Summer Lane – Drainage Comments From Paul Cann (12th May 2020)

Response Not further action

Information will be provided by Drew Smith

Headwall Cross Section

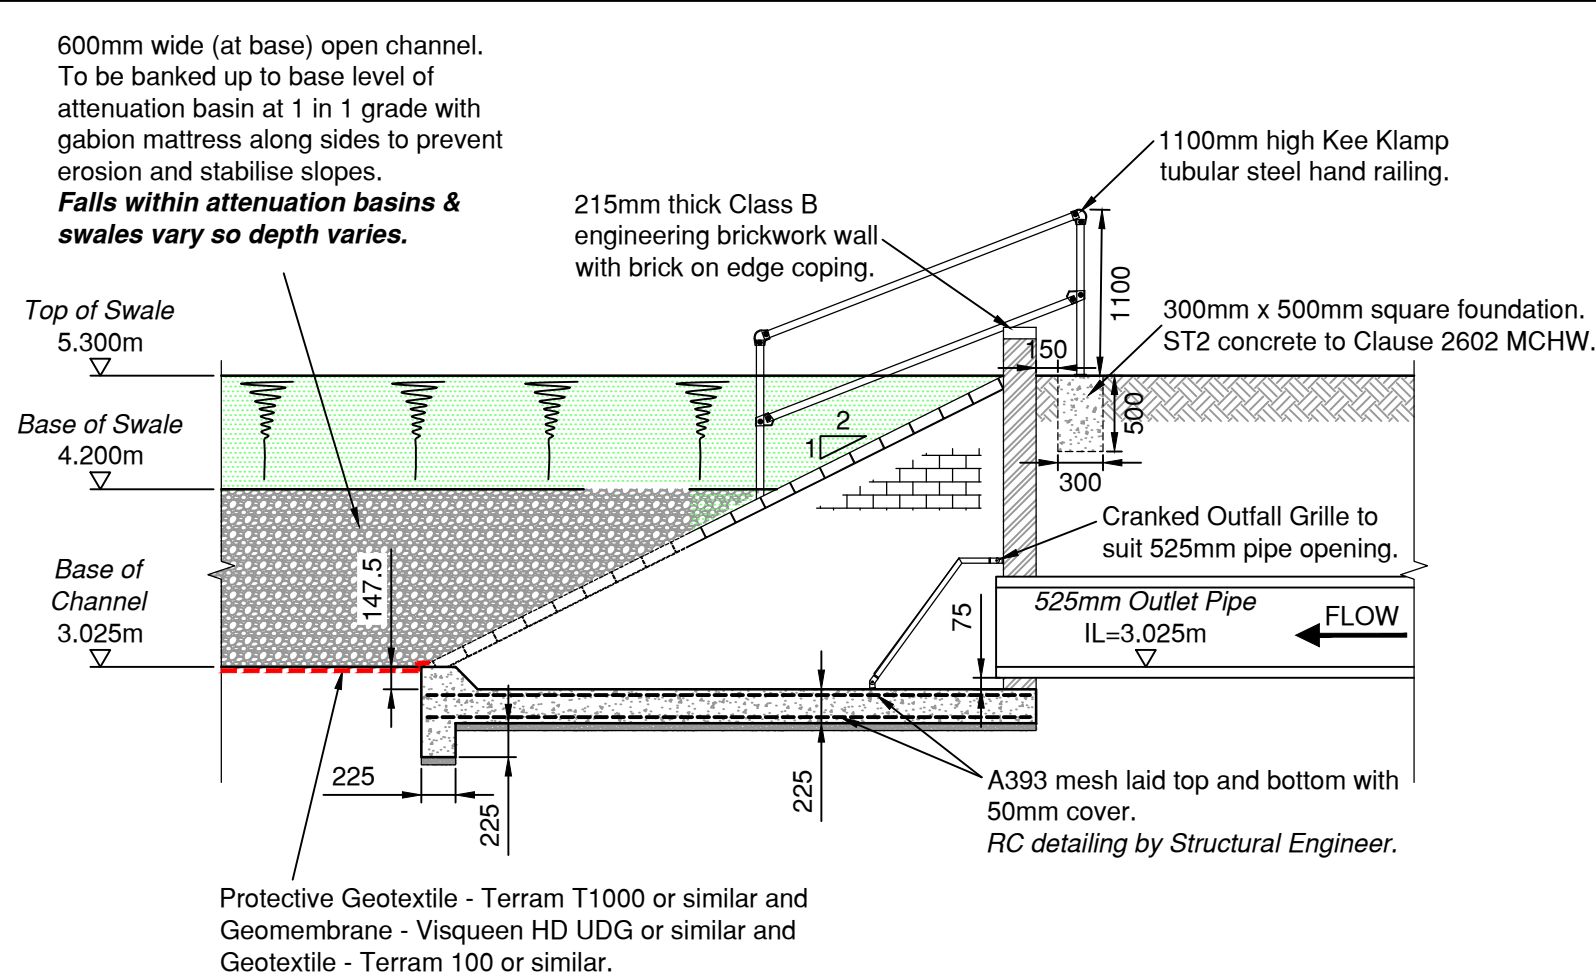
9. All headwall grilles to be cranked as opposed to be flat or just sloped faced. Headwalls SW-4, SW-5, SW-9, SW-13, SW-29 and SW-32 updated to cranked grilles.

12. All headwalls - 50mm cover required to reinforcement. Drawings 433 and 434 updated with concrete cover note increasing from 40mm to 50mm.
13. All headwalls – Dimension and specify concrete for hand railing foundations. Dimension handrail height above ground level and offset from brickwork. Drawings 433 and 434 updated with handrail dimensions and foundation annotation.

17. Incoming pipes at headwalls SW-4, SW-5 and SW-32 – increase freeboard between pipe inverts and basin/swale bed. The base of the pipe work connects to the drain bed level, which is specifically deepened to accommodate the incoming pipework levels and eventually connect onto the downstream watercourse. This is a similar arrangement to the main drainage channel running through the swale associated with headwalls SW9 and Sw13.

Drawing Title:-
NORTH DITCH
HEADWALL
CONSTRUCTION DETAILS

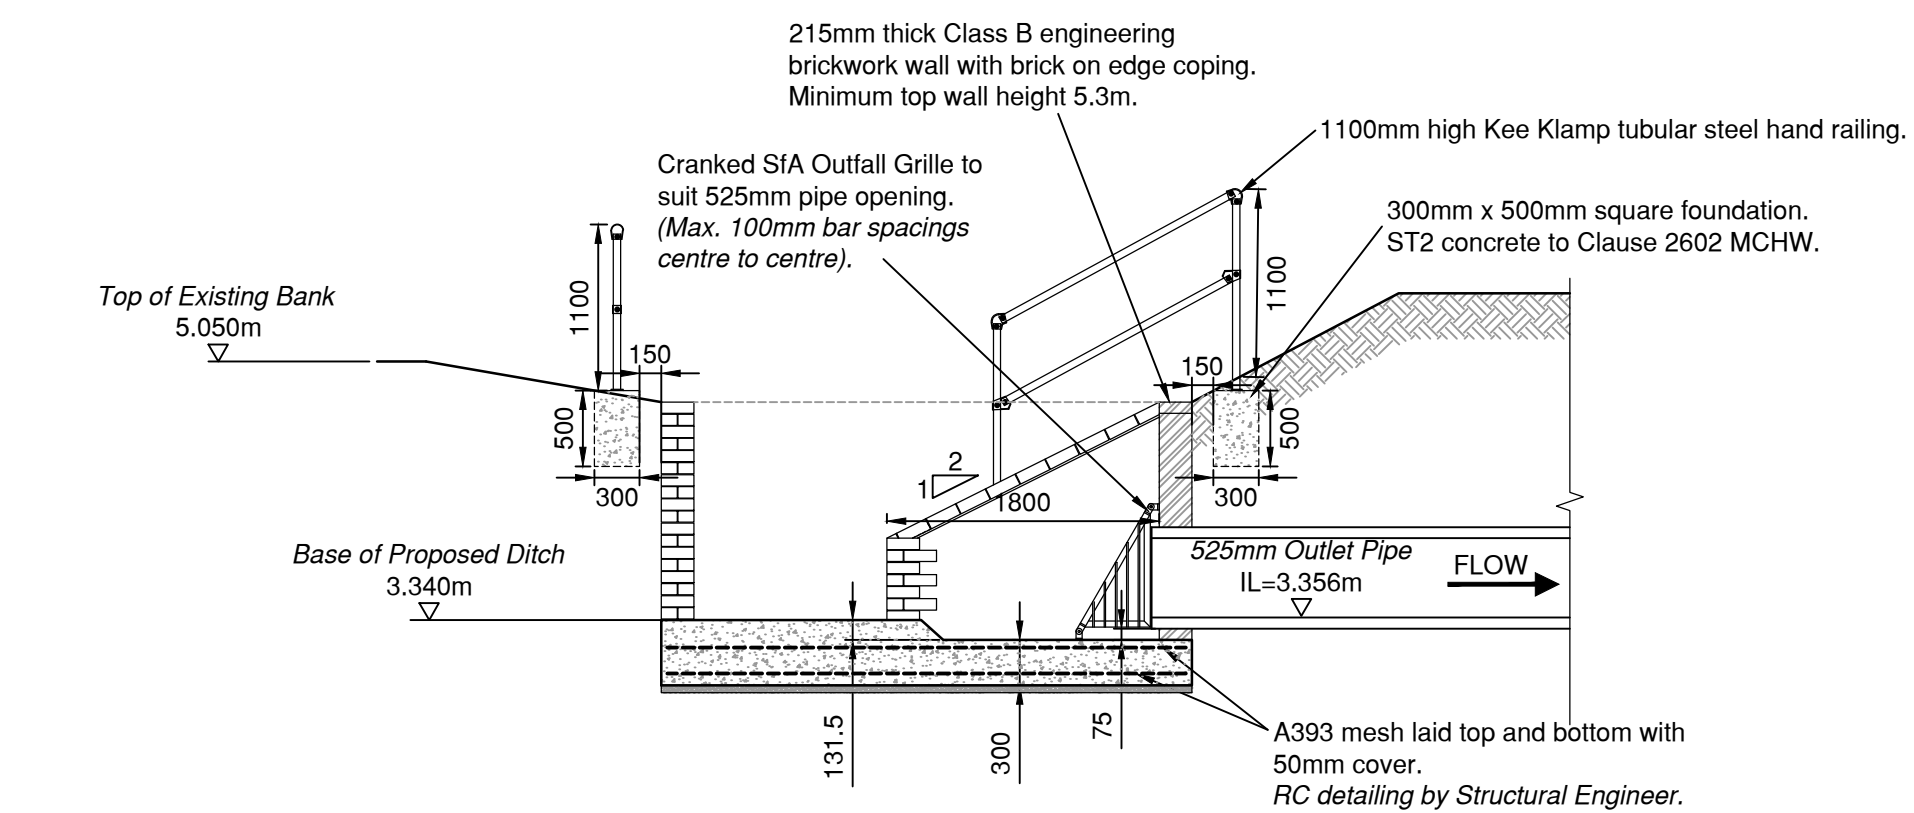
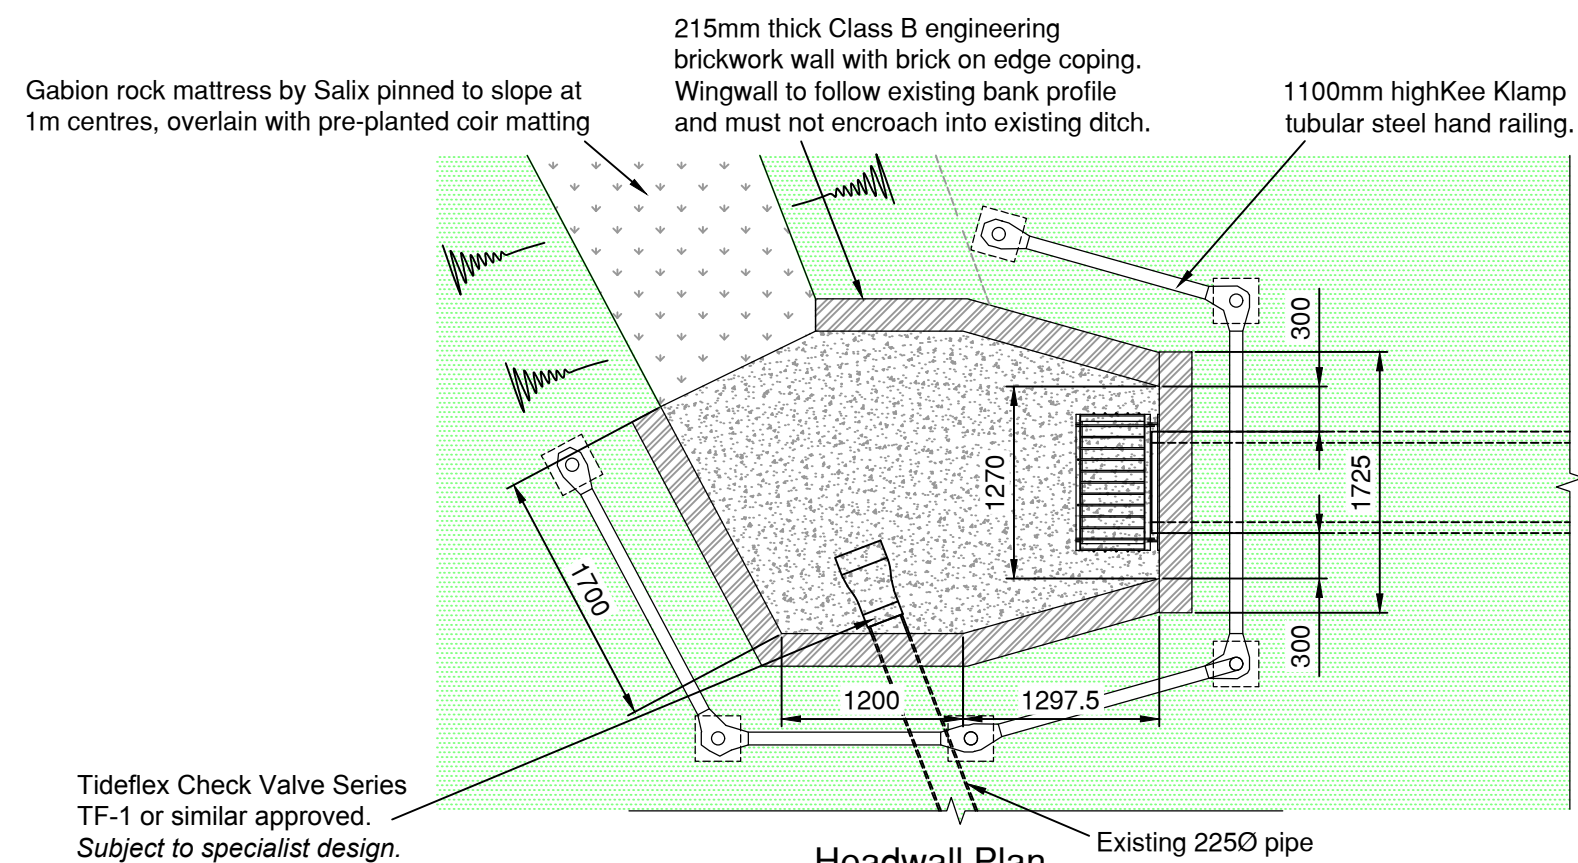
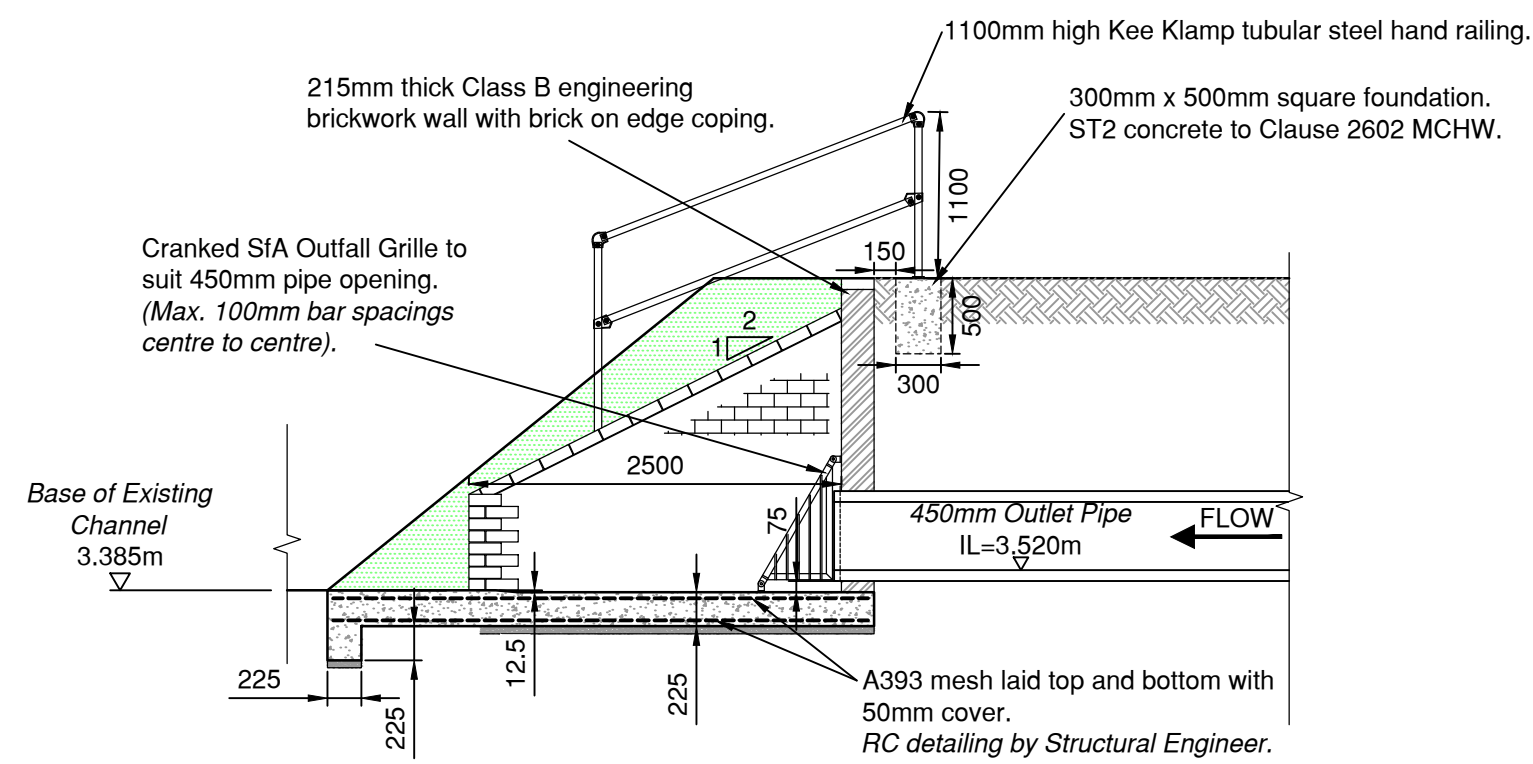
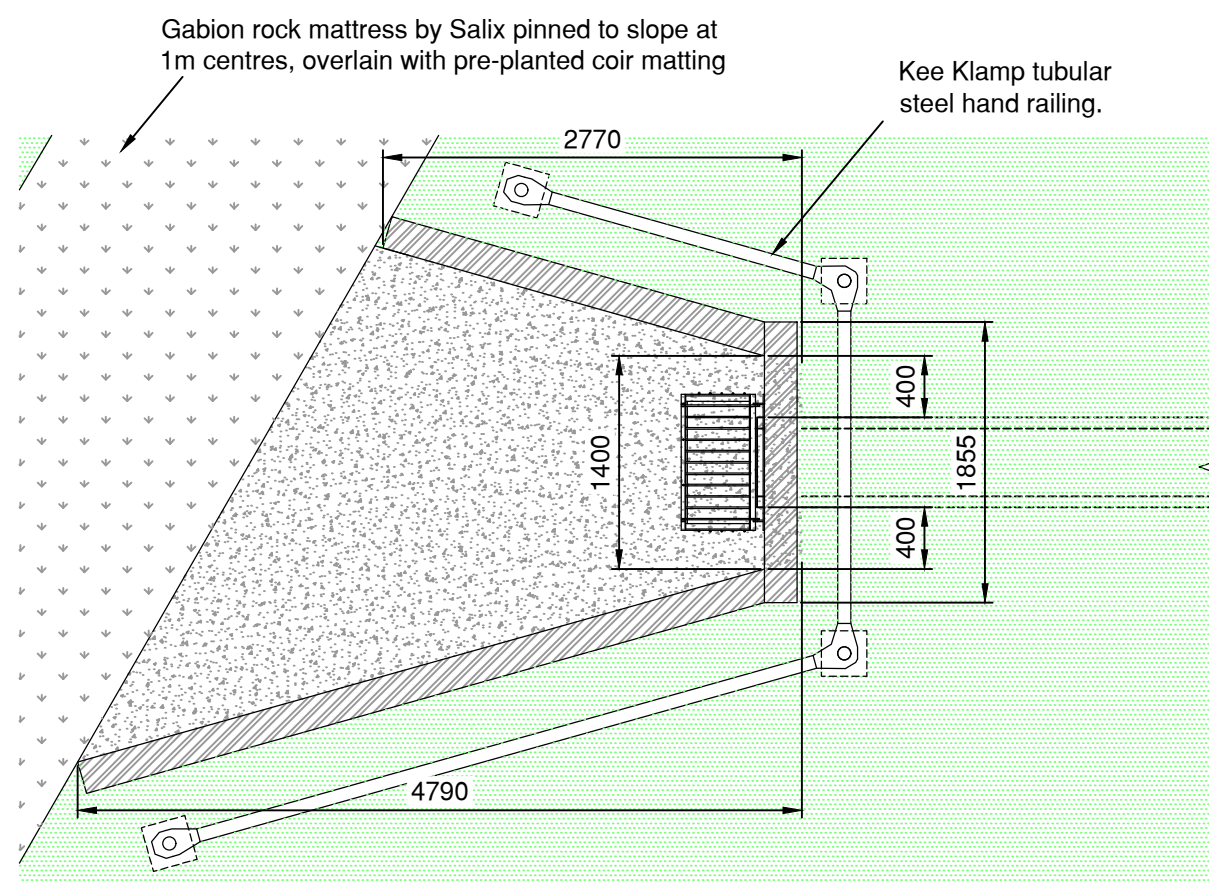
10. Provide construction detail for headwall SW-14. Per OWC – will be provide a copy of these along with this response as well
11. Headwall SW-1 construction detail – remove grille. Indicate proposed ditch bed level , pipe invert level and diameter. Concrete capping to be ST4 or similar approved. Per OWC – will be provide a copy of these along with this response as well
